**CITY OF PORTLAND, MAINE  
DEVELOPMENT REVIEW APPLICATION  
PLANNING DEPARTMENT PROCESSING FORM  
DRC Copy**

35 Providence  
Project Name/Description

**Approval Conditions of DRC**

PLAN SHOWING A STANDARD BOUNDARY SURVEY MADE FOR
MARK FLOURDE
 PORTLAND, MAINE

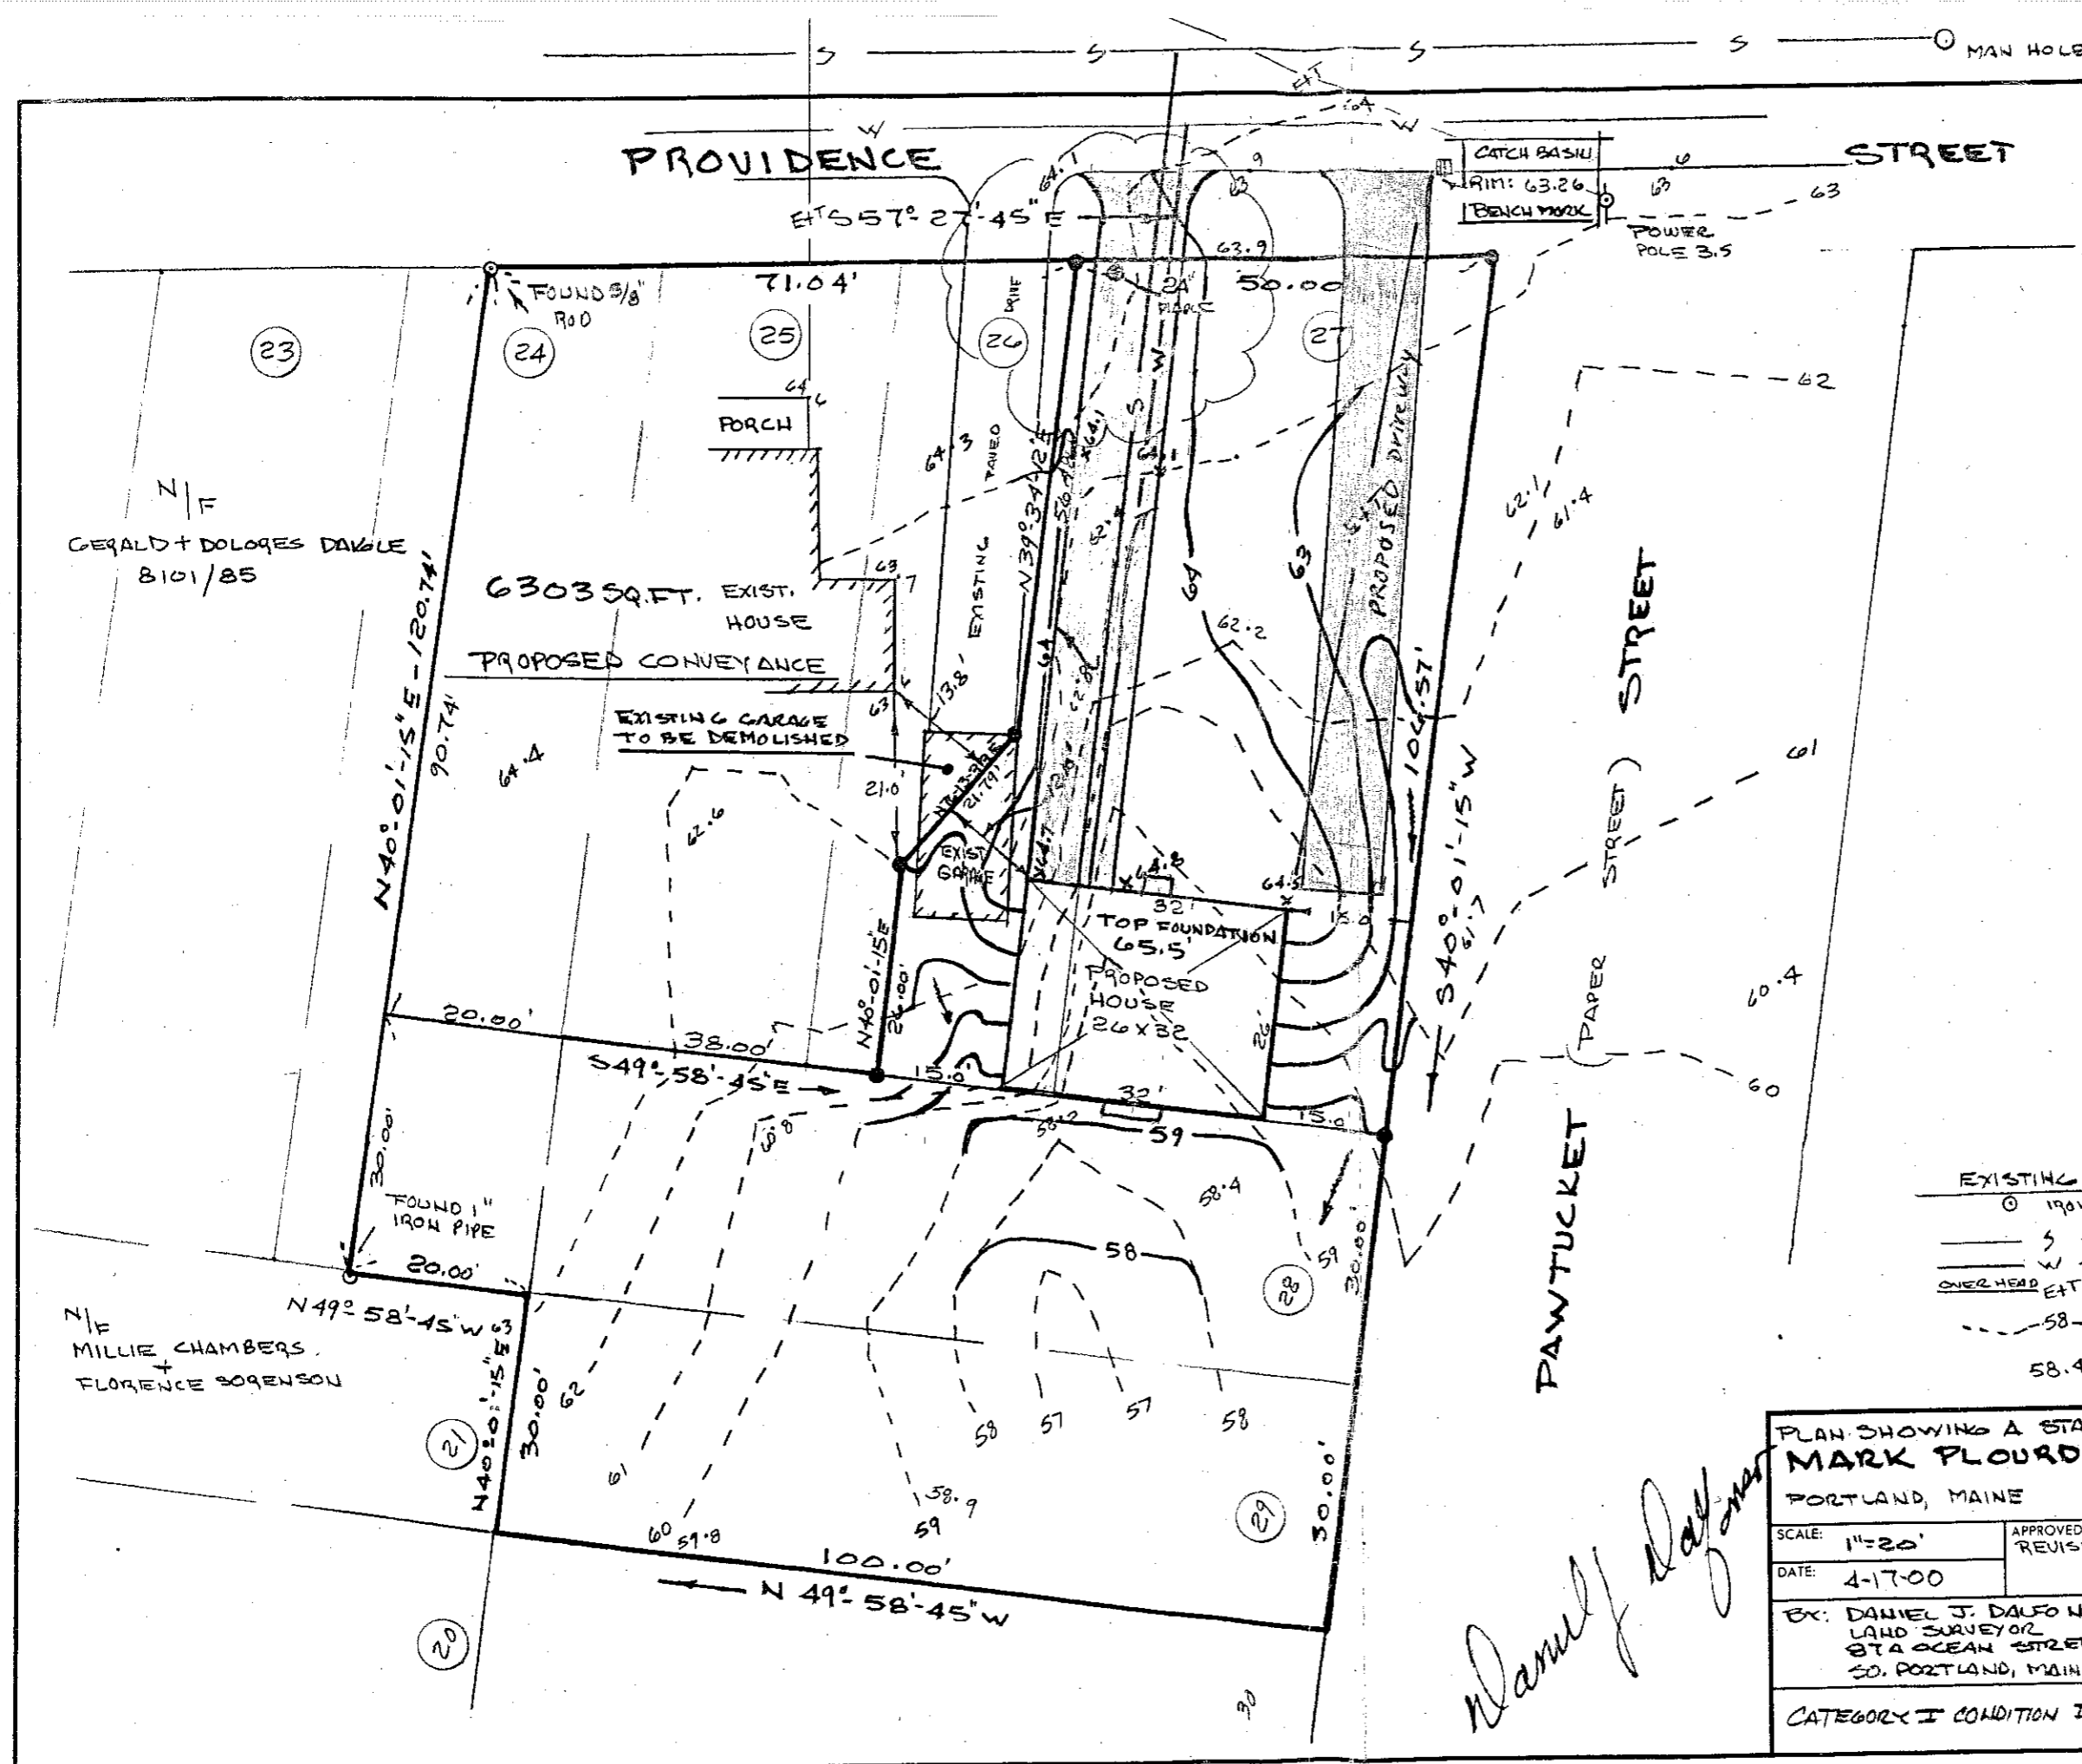
- 1 A CLEANOUT WILL BE REQUIRED ON THE SEWER LEAD.
- 2 All damage to sidewalk, curb, street, or public utilities shall be repaired to City of Portland standards prior to issuance of a Certificate of Occupancy.

- 3 Two (2) City of Portland approved species and size trees must be planted on your street frontage prior to issuance of a Certificate of Occupancy.
- 4 Your new street address is now #33 Providence Avenue, the number must be displayed on the street frontage of your house prior to issuance of a Certificate of Occupancy.

- 8 The Development Review Coordinator reserves the right to require additional lot grading or other drainage improvements as necessary due to field conditions.
